| Our Ref: | NE/22/00422/FUL |
| Date: | 7 April 2022 |

Proposal: Single storey front extension (re-submission of NE/21/00666/FUL) at 1 The Drift Collyweston Stamford PE9 3PH.

Drawing  
**Floor Plans as Proposed**

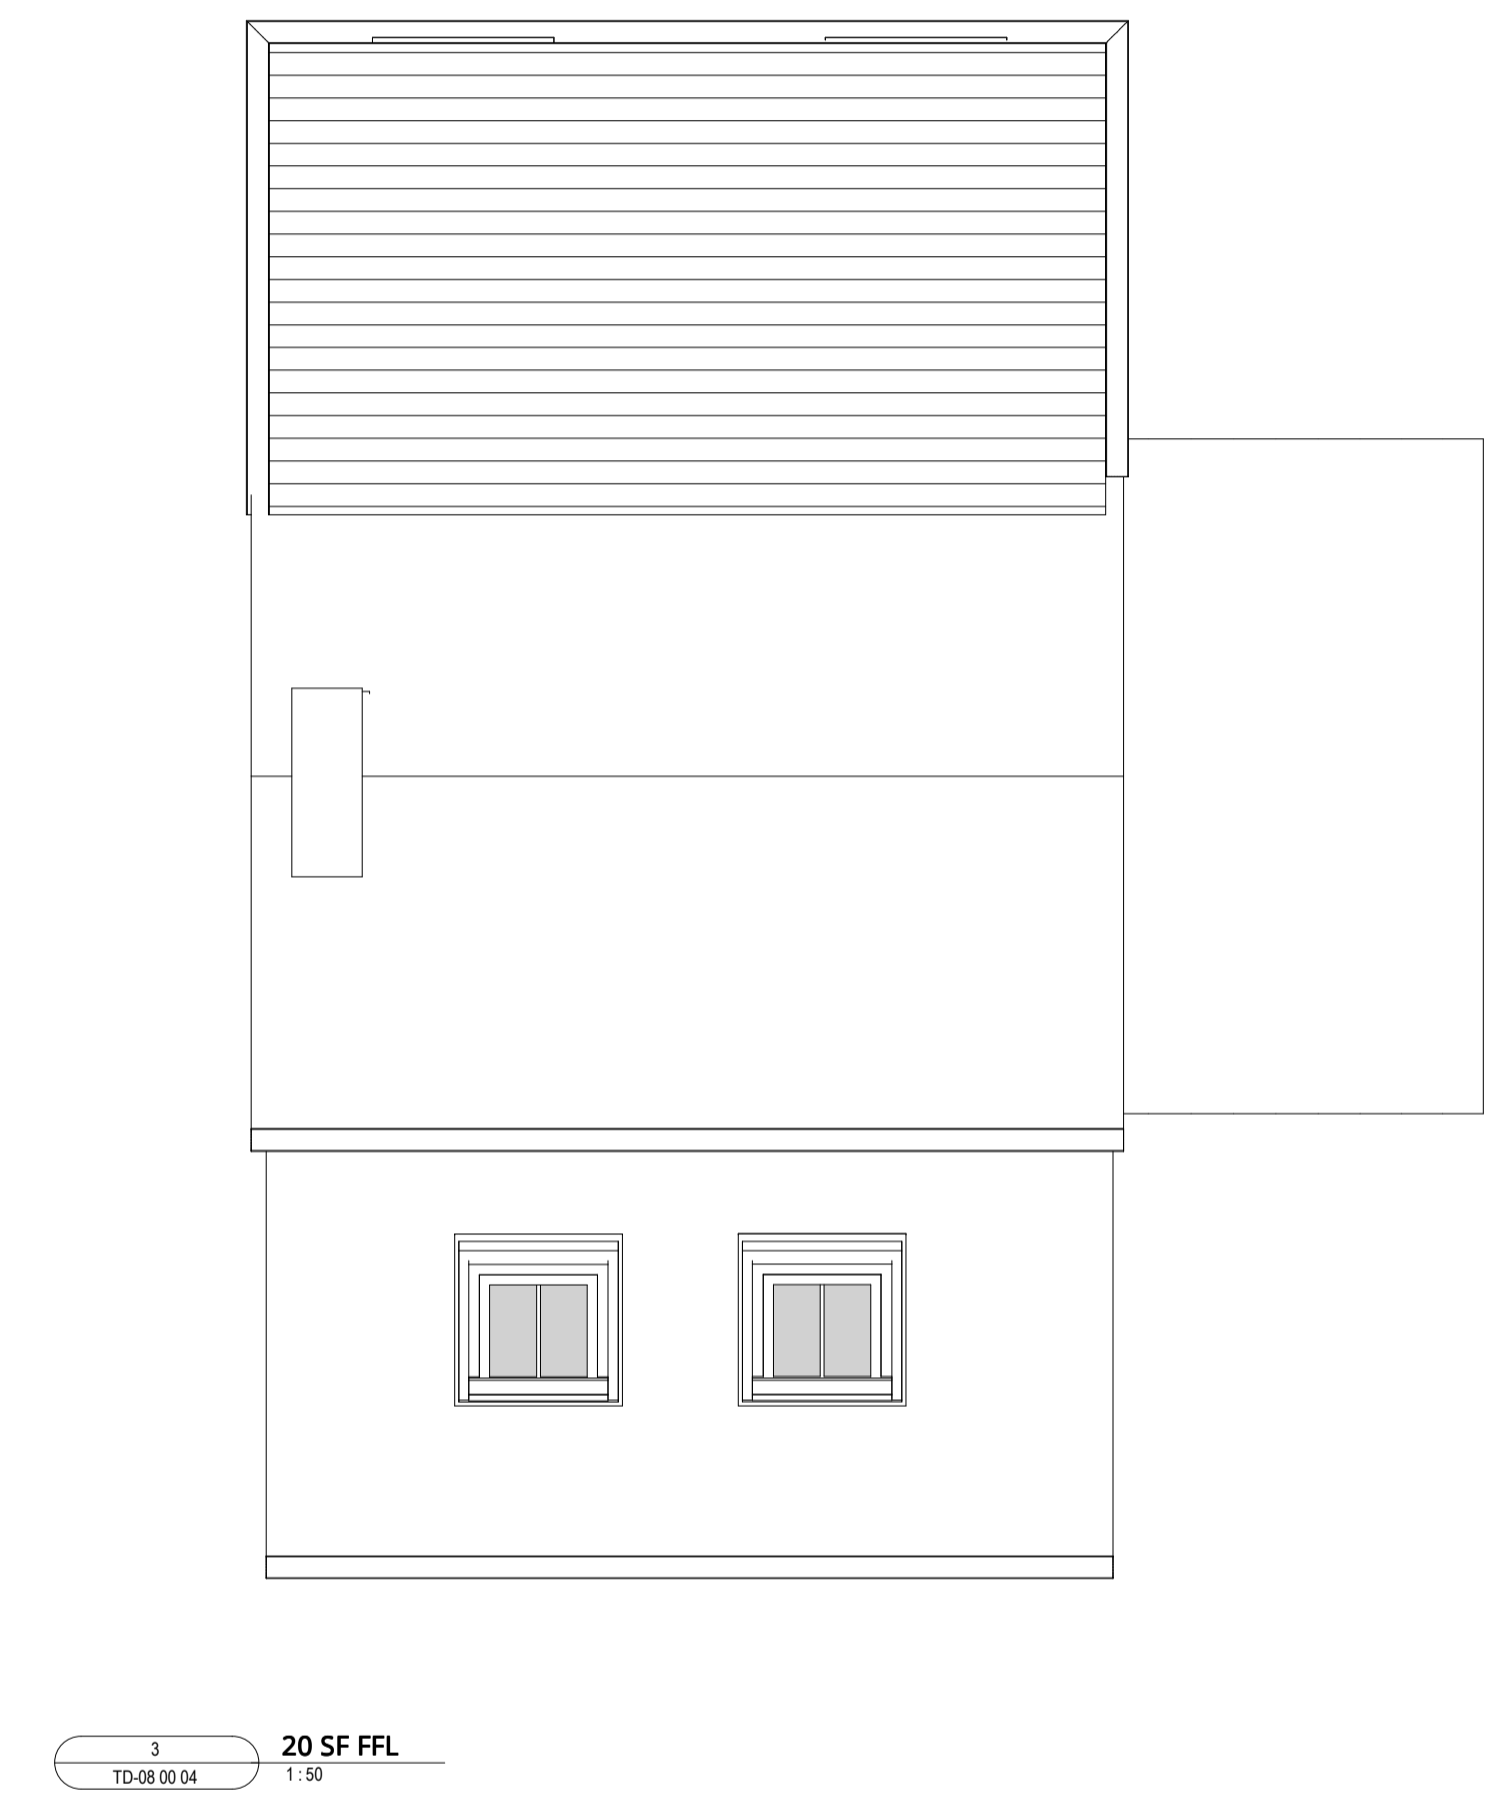
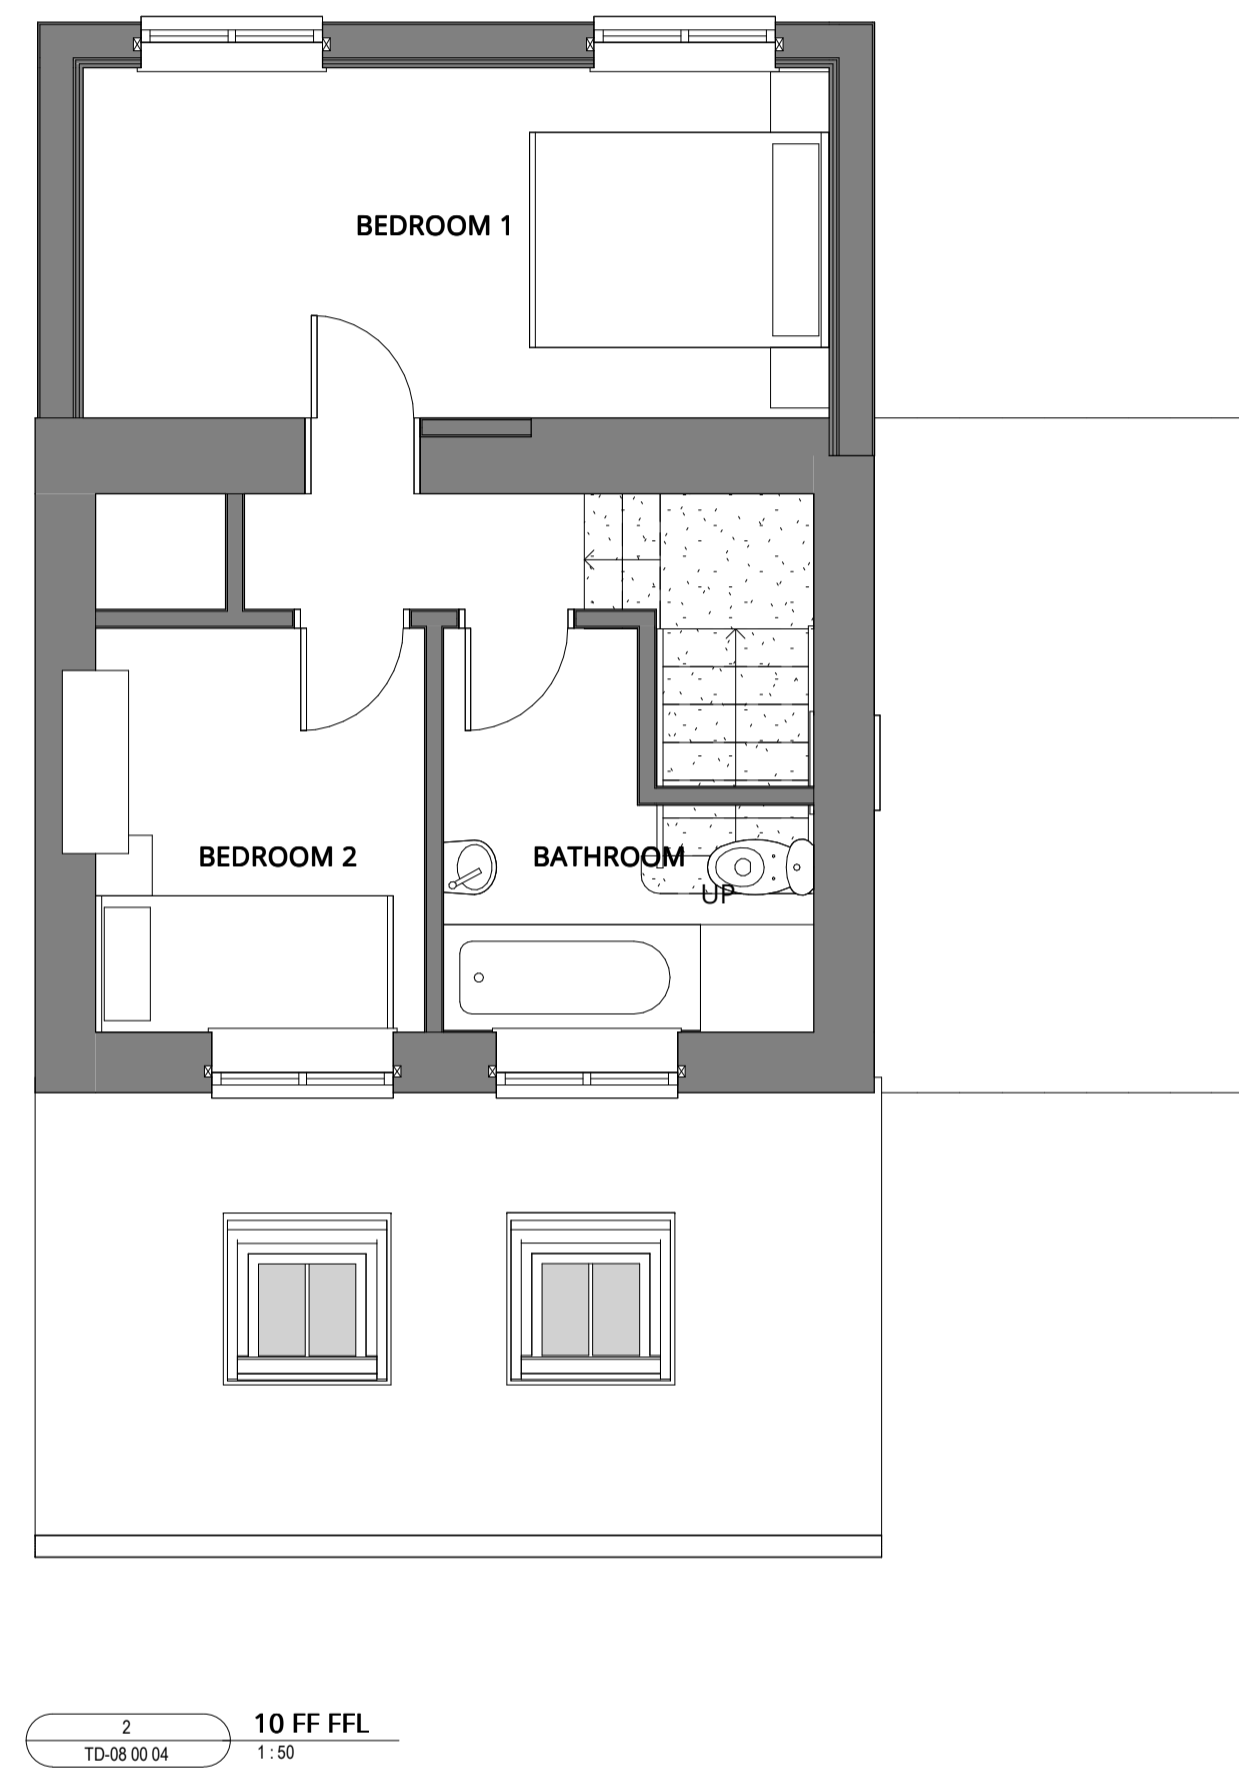
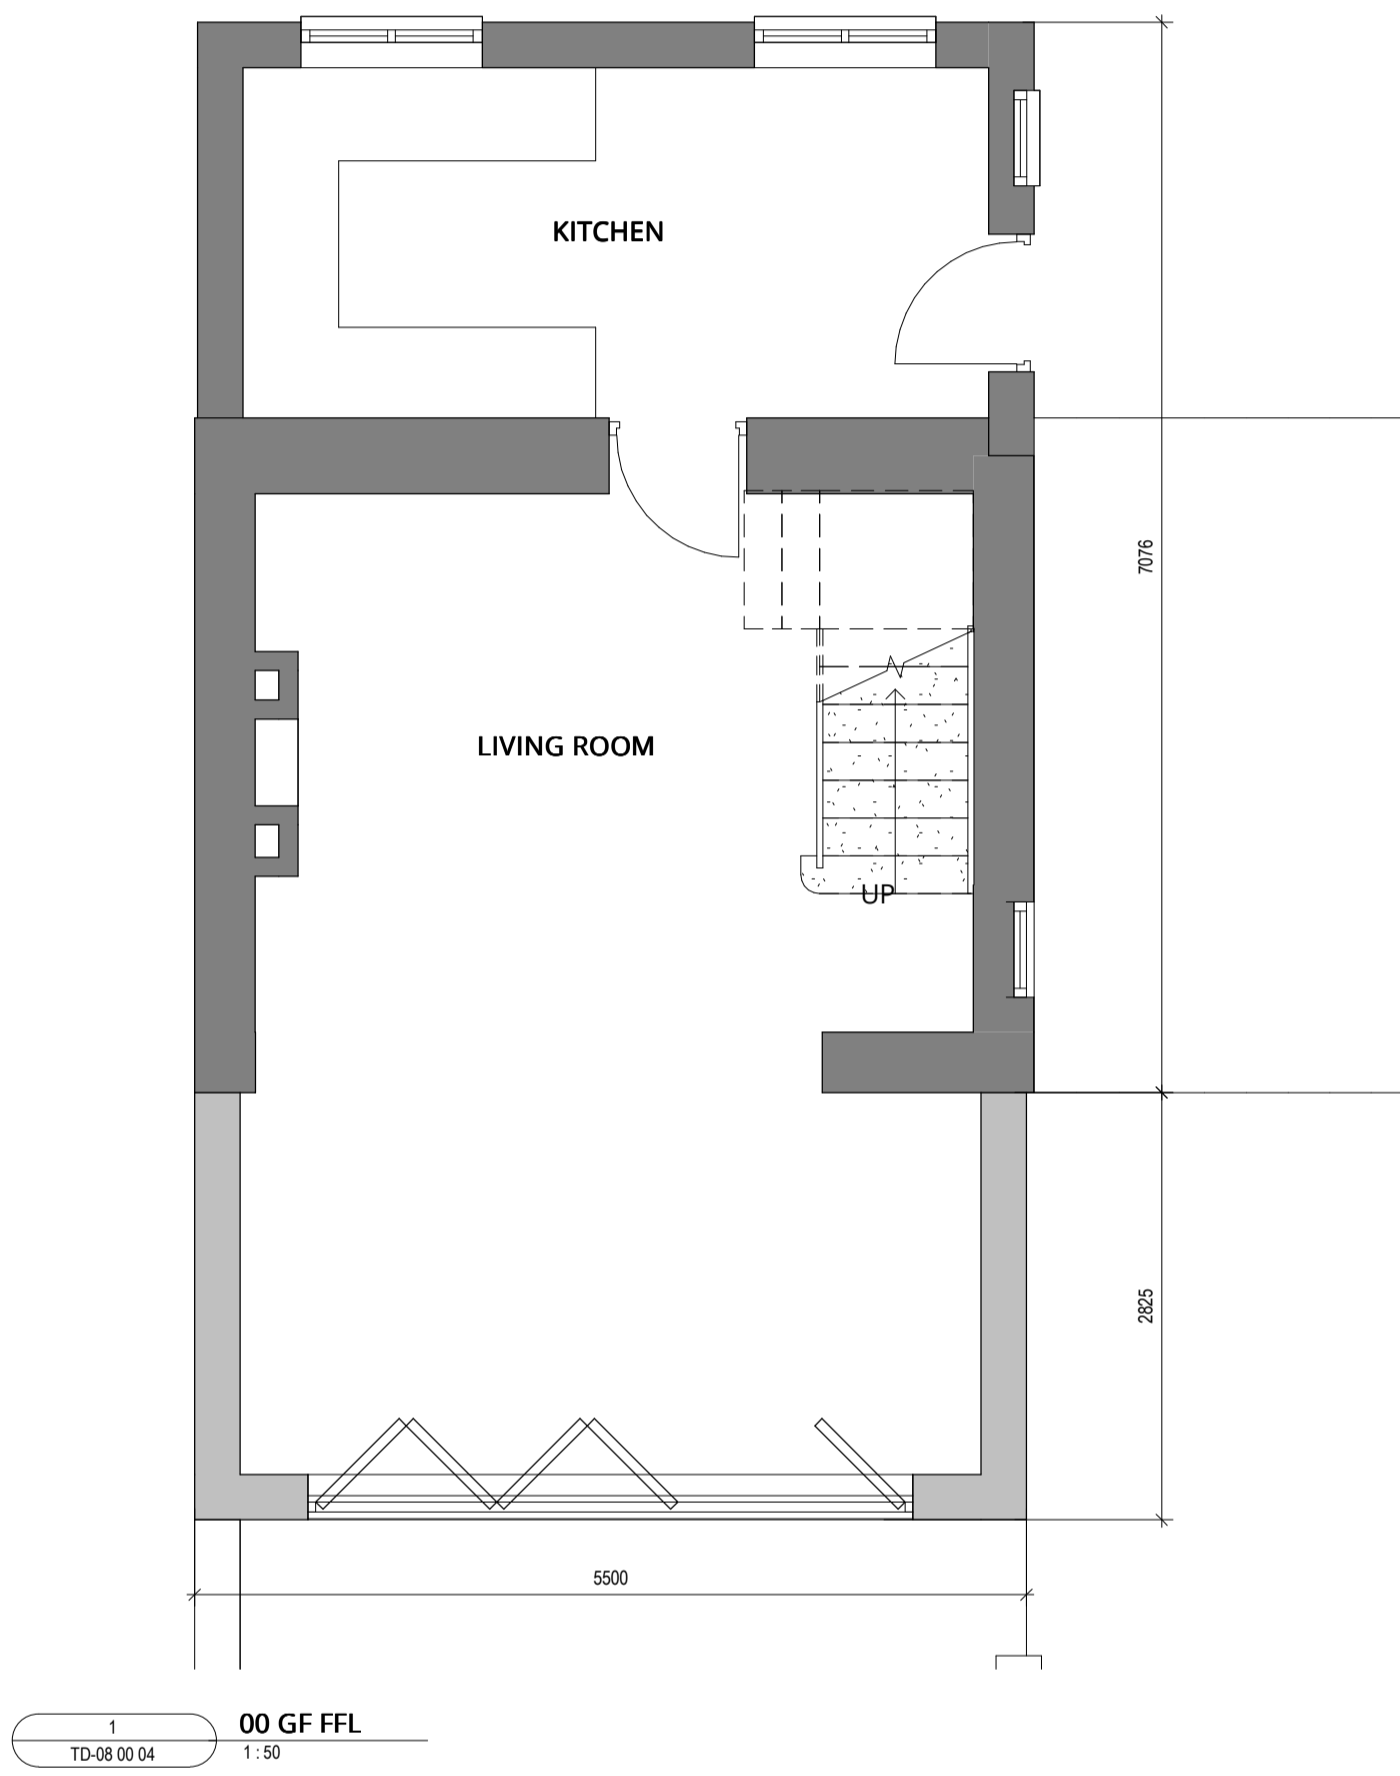
1. Thank you for the drawings submitted with your application, even though the scale used has been given all the relevant dimensions have not been provided. As per our published Local Requirements, "All plans and drawings must be drawn to an appropriate metric scale (1:50 or 1:100) and have all relevant dimensions of the key elements of the proposal clearly written. This includes the height, length, width and (if relevant) the distance from the site boundary of any proposed works. We require this so that the proposed dimensions are clear when plans are viewed online." This is required as we now run a completely paperless planning office.

Please provide amended drawings including all relevant dimensions of the proposal:

- Dimensions for the existing and proposed floor plan
- Dimensions for the existing and proposed elevations annotated with all height dimensions

2. As per our local requirements, please provide a proposed site plan showing your proposals for the new works in relation to the site boundaries and other buildings within and surrounding the site; on-site parking and the distance from the site boundaries to the proposed works.
3. I note that there is a "Do not scale" statement on the submitted drawings, as per our local requirements drawings should be accurate. Ambiguous statements such as "Do not scale", "Not to scale" etc. call the accuracy of the drawing into question.

Therefore, please give your written authorisation for this statement to be removed from the drawings or to be altered to read "For planning purposes only". On amended drawings, submitted please remove or alter this statement.
